Mountain View Electric Association, Inc. (MVEA) has these comments about the following:

Project Name: Settlers Ranch, Filing #2C

Project Number: SF 1818

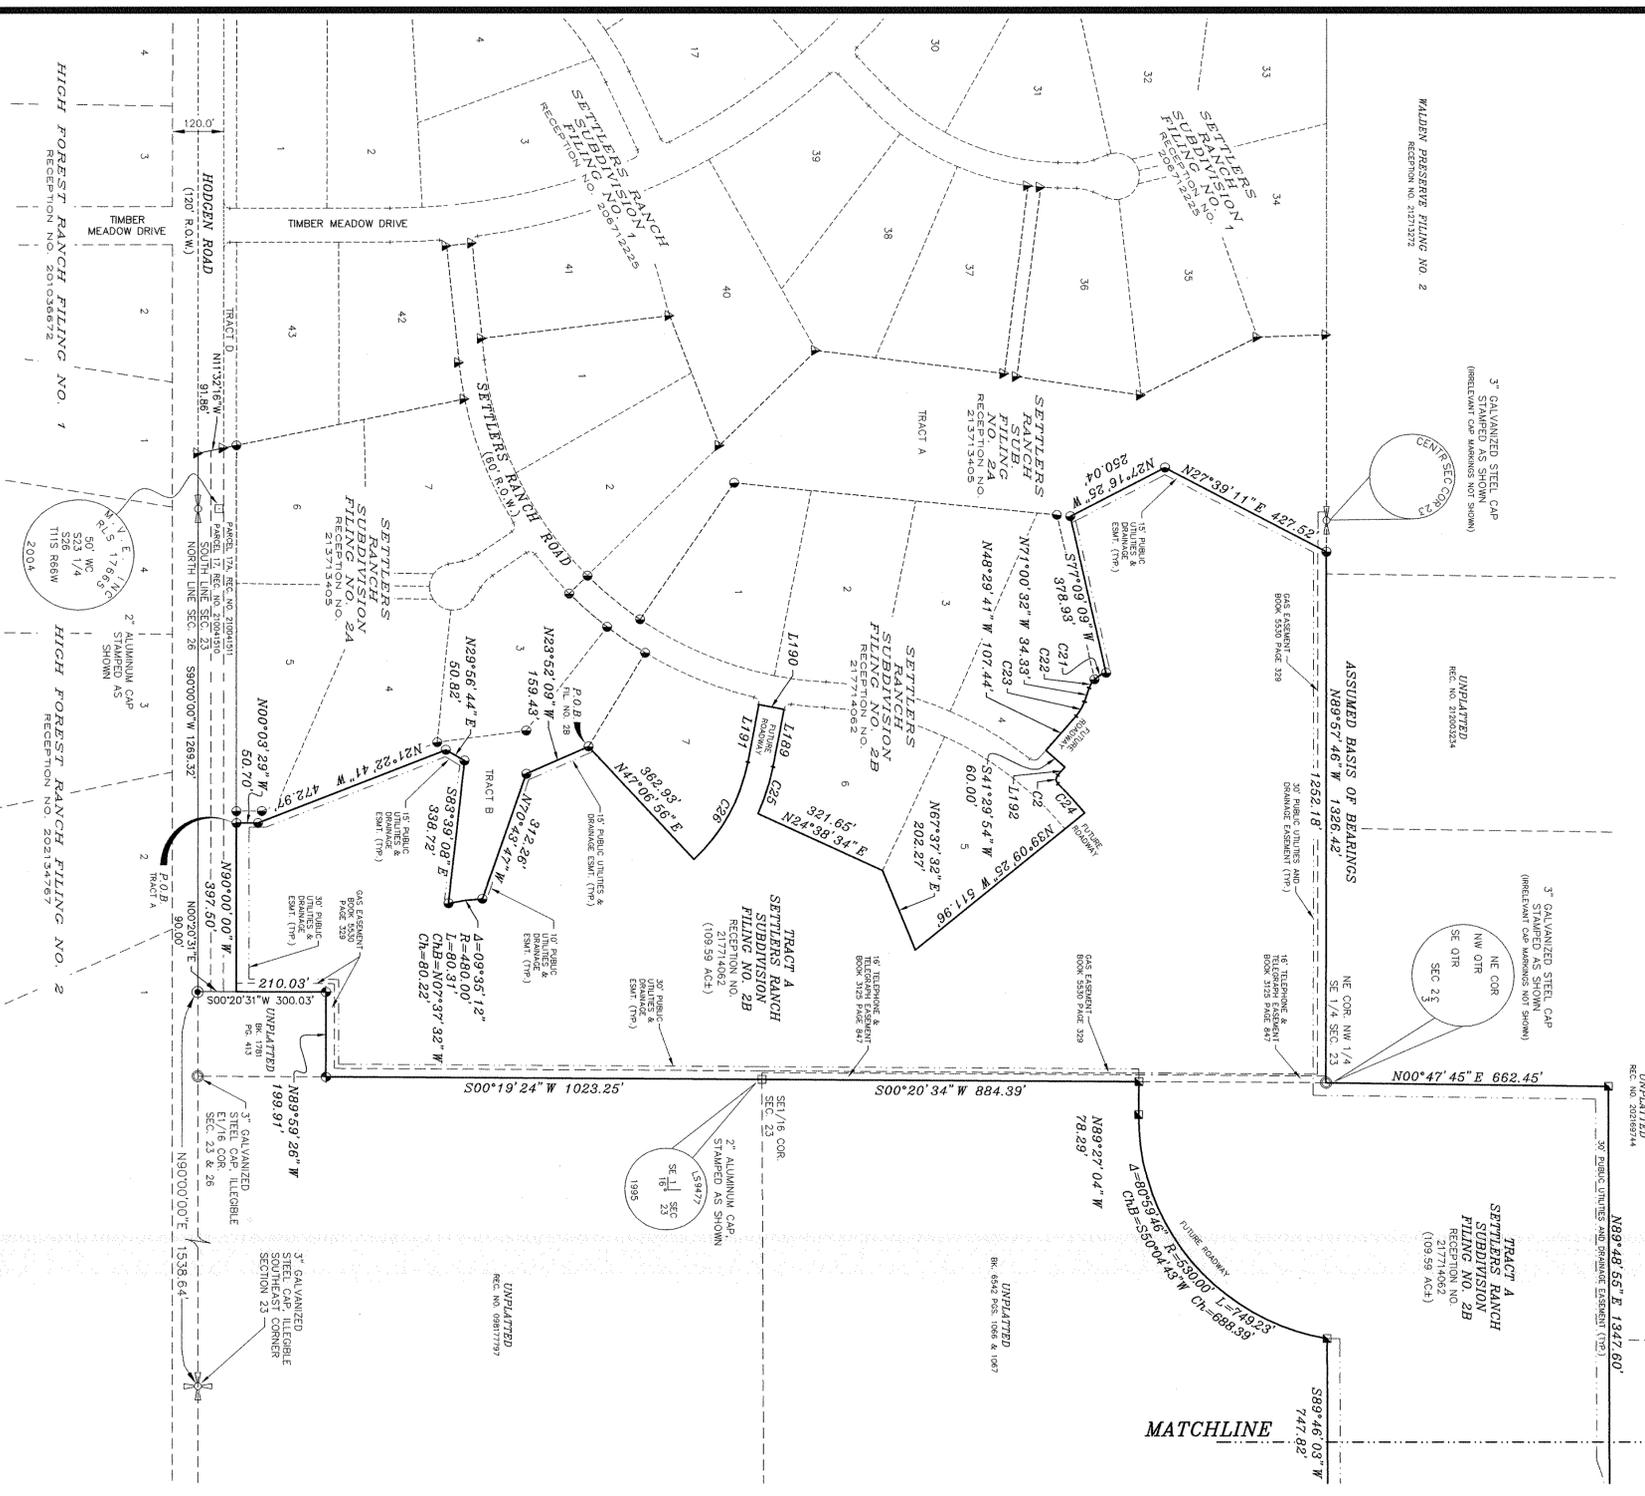
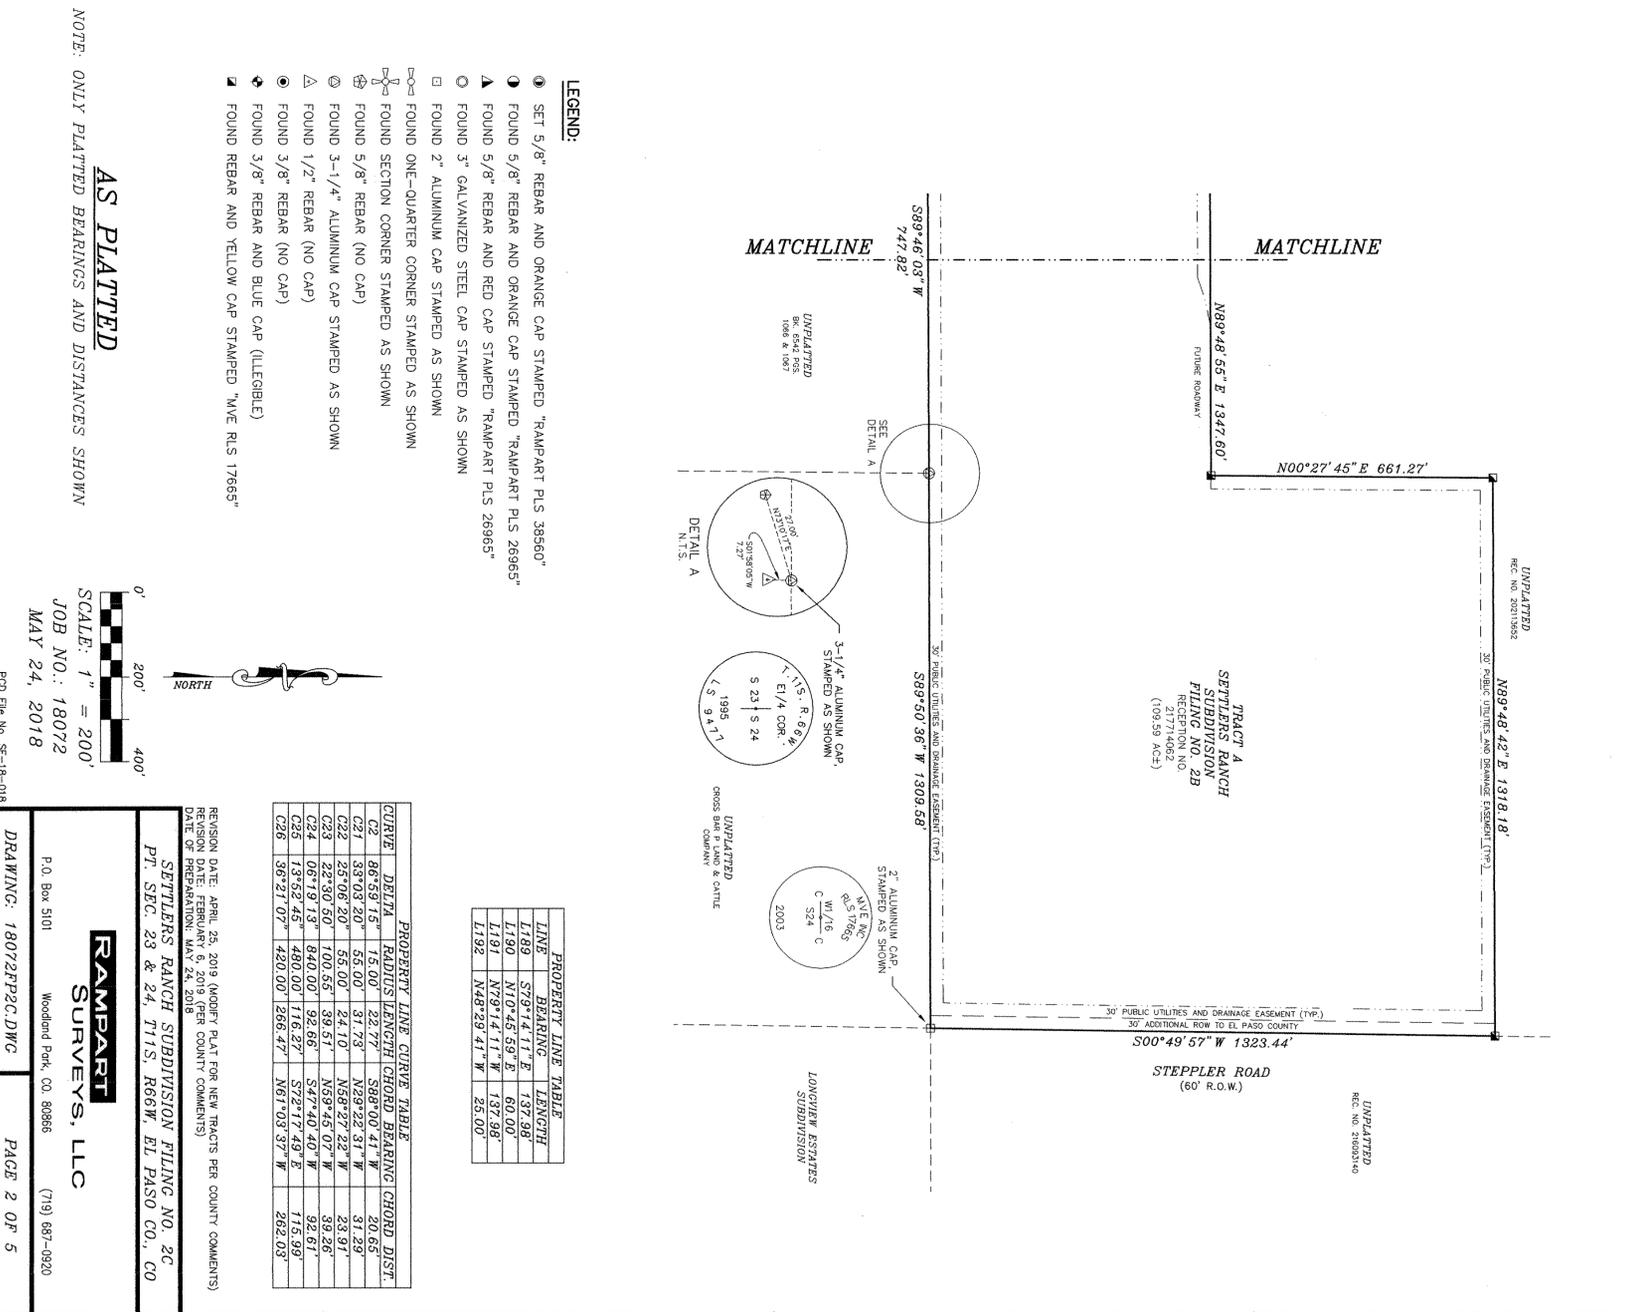
MVEA acknowledges the easements shown in the plat of ten (10) foot side, fifteen (15) rear and twenty (20) foot front lot line utility easement along with a thirty (30) foot exterior easement on plat. MVEA request utility easements be included with the Public Improvement Easements along the front lot and tract line to aid in the design and the platting of existing MVEA facilities with easement on the plat. If open space, drainage and landscape tracts are designed in this filing MVEA requests these areas be listed to include utilities. Additional easements may be required once a review of civil drawings with grading and erosion plan is provided to MVEA in order to serve this subdivision.
